Article 21 of the Town and Country Planning (General Development Procedure) Order 1995
Application for approval of details reserved by condition 4 (trees/shrubs) relating to planning
application EG/64/12/
Tars Farm Church Lane, Barnham,

Arun District Council have decided to **REFUSE details reserved by condition for the following reasons:**

Proposal

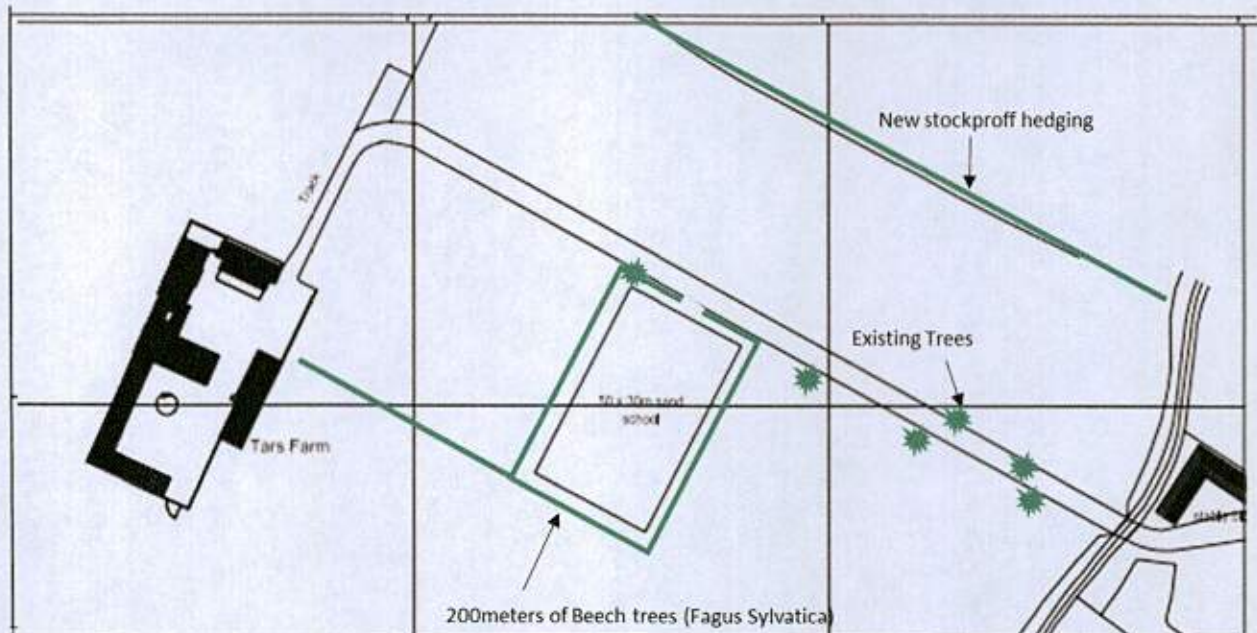
The submitted landscape scheme as detailed within the submitted Landscape Statement dated 07/09/14 is not considered to be acceptable in that: (a) the landscape scheme relates to a menage which has been sited in a slightly different position to that shown on the approved plans and also shown within the submitted Landscape Statement; and (b) the Councils Landscape Officer has objected to the discharge of the condition.

The condition is therefore not discharged and you will need to apply for a variation of the plans condition (02) attached to EG/64/12. You can either attach the landscaping scheme to the variation of condition application as we may then reword the condition so as not to require a further submission. Alternatively, once that has been approved, you can submit a second approval of conditions application which relates to the condition on the new approval.
